Your ref: SSD 30923027
File no: MC-22-00001

SSD 30923027 – Compass 2 Warehouse and Distribution Centre, Eastern Creek Drive, Eastern Creek

Blacktown Council's submission to SSD 30923027– Compass 2 Warehouse and Distribution Centre

1. Drainage Comments

Costin Roe Consulting Pty Ltd.
Consulting Engineers
Level 1, 8 Windmill Street
Wahia Bay, Sydney NSW 2000
Tel: (02) 9261-7899 Fax: (02) 9241-3731
email: mail@costinroe.com.au @DESIGNED
S.M.DRAWN
J.W.DATE
OCT 21CHECKED
B1SCALE
AS SHOWNCAD REF:
C013003.13-SSDA40

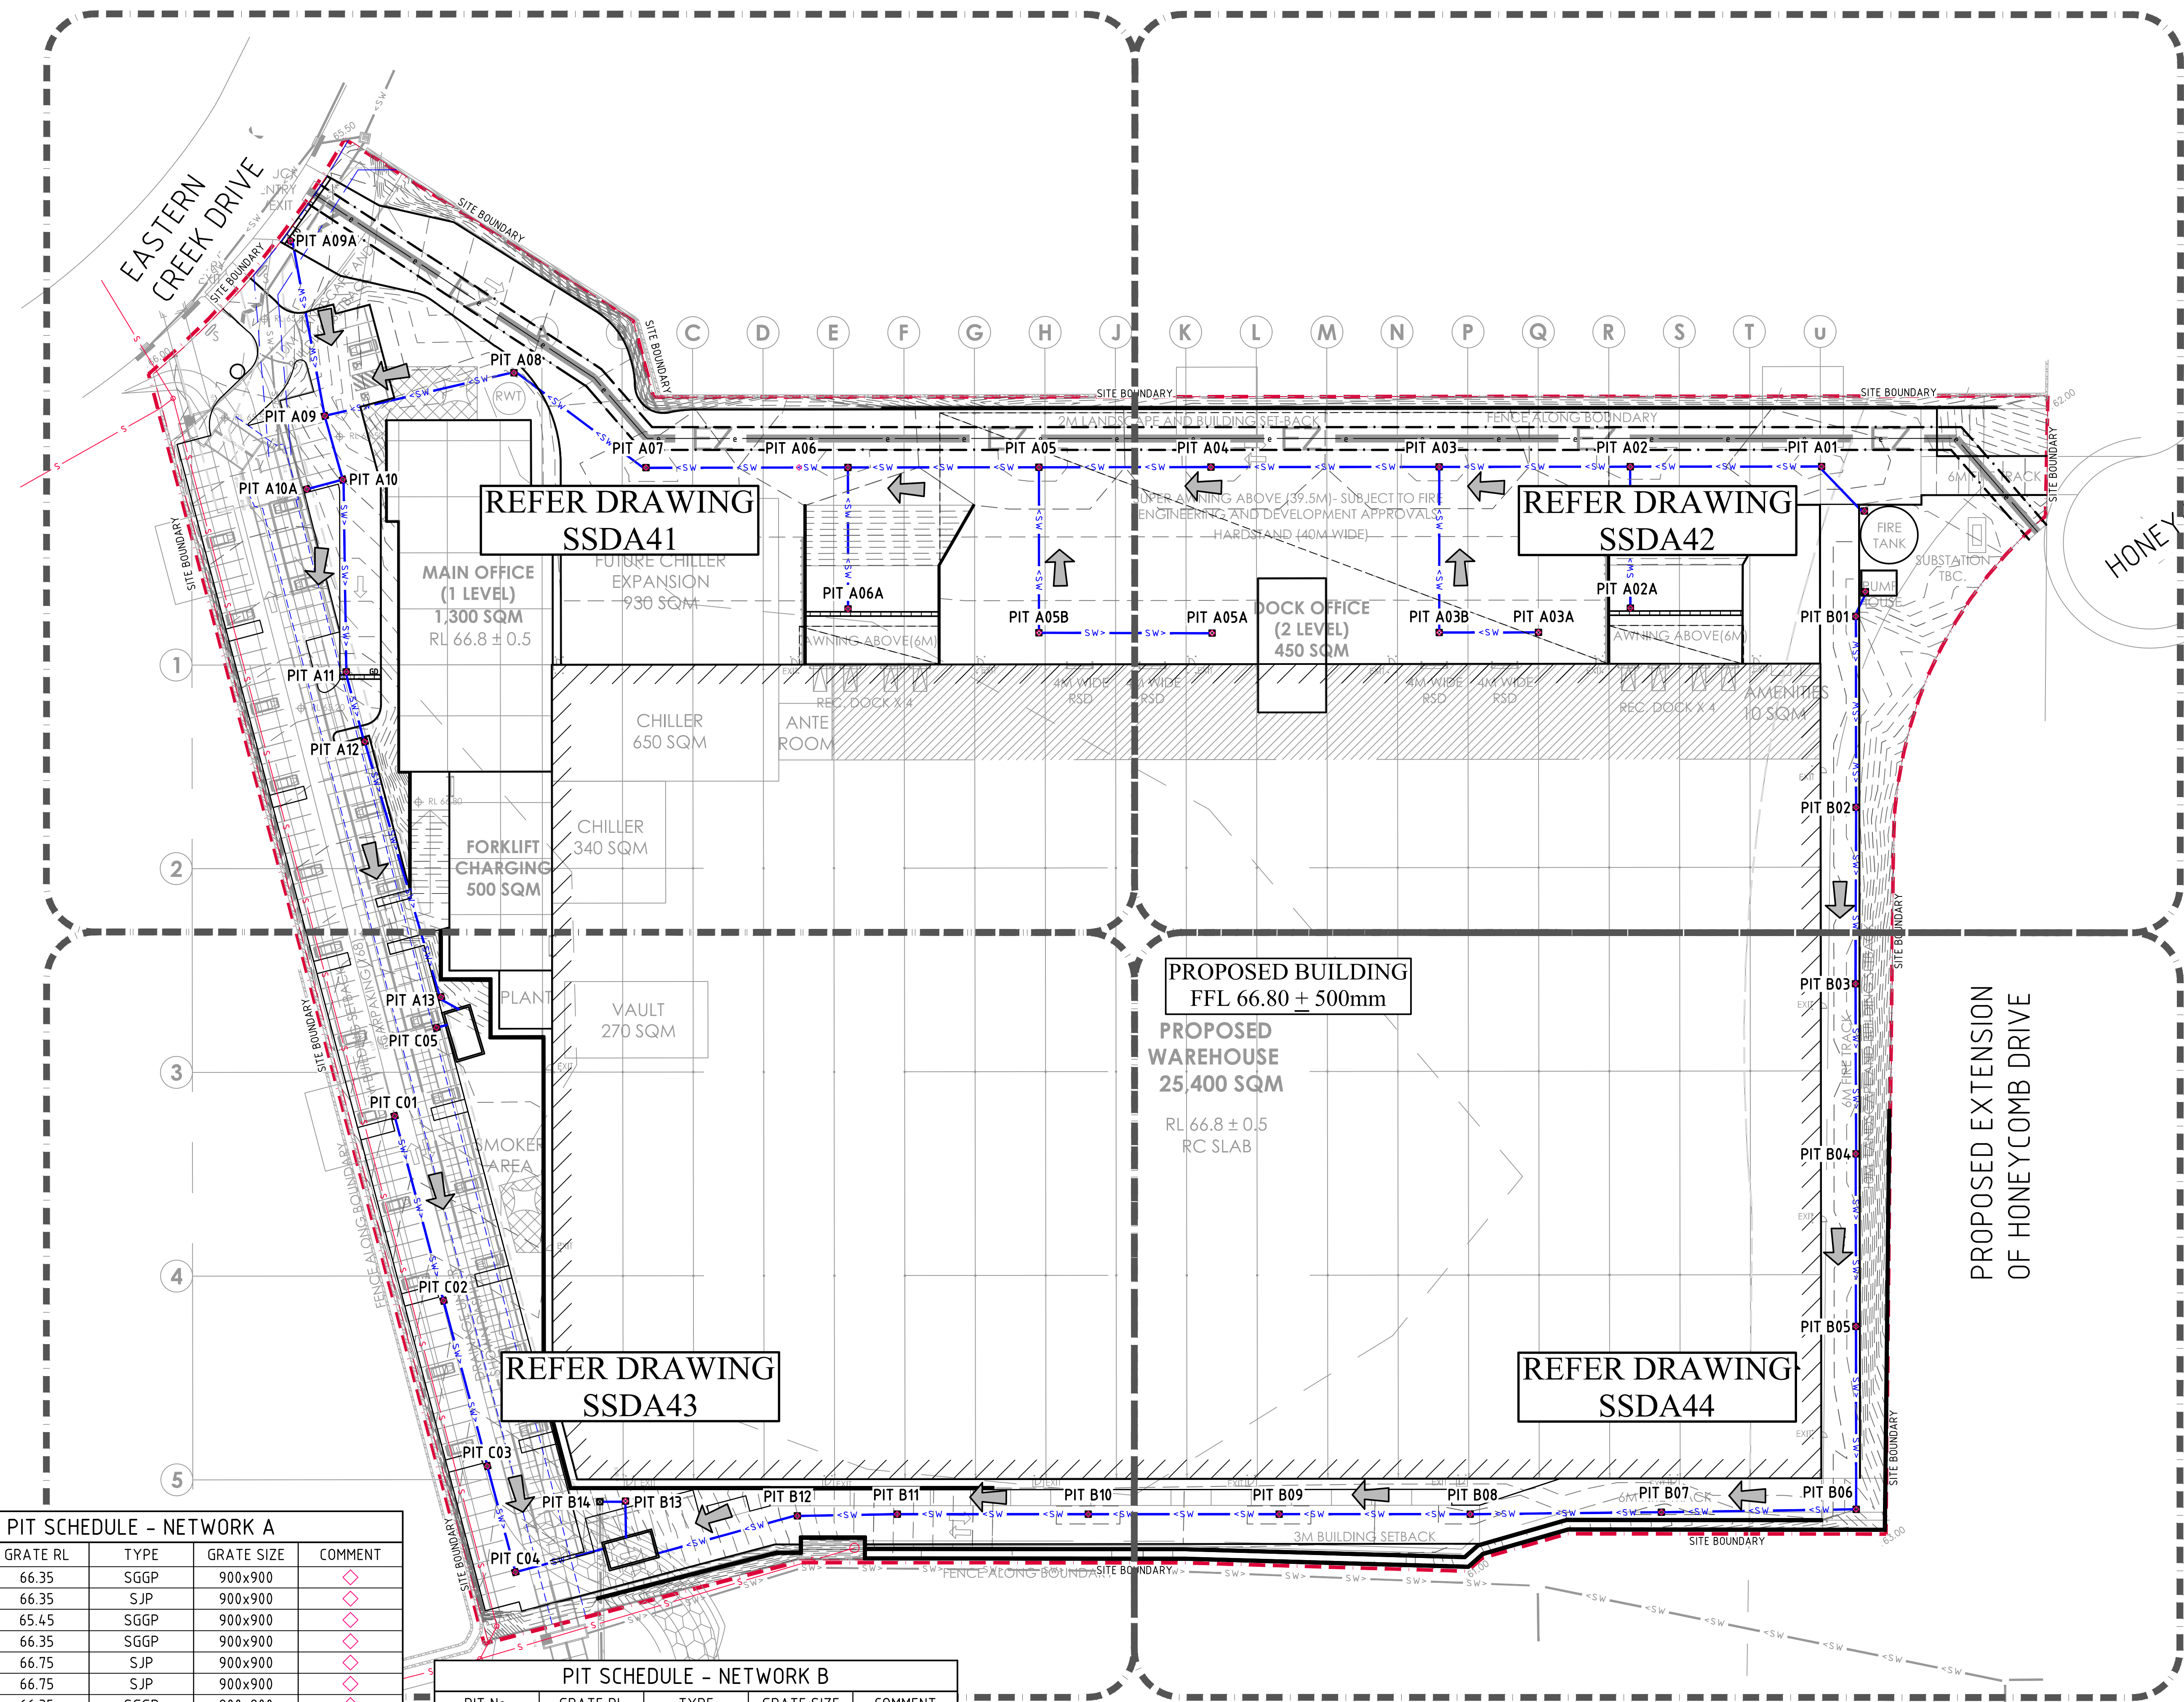
- Drawings SSSDA40 (J), SSSDA41 (I), SSSDA42 (I) and SSSDA43 (H) and SSSDA44(G):
 - Dual downpipes are proposed where the low flow pipe is directed to the bioretention basin and high flow pipe to Pit A10. Provide details of how the flows from the roof will be split to allow this arrangement to work.
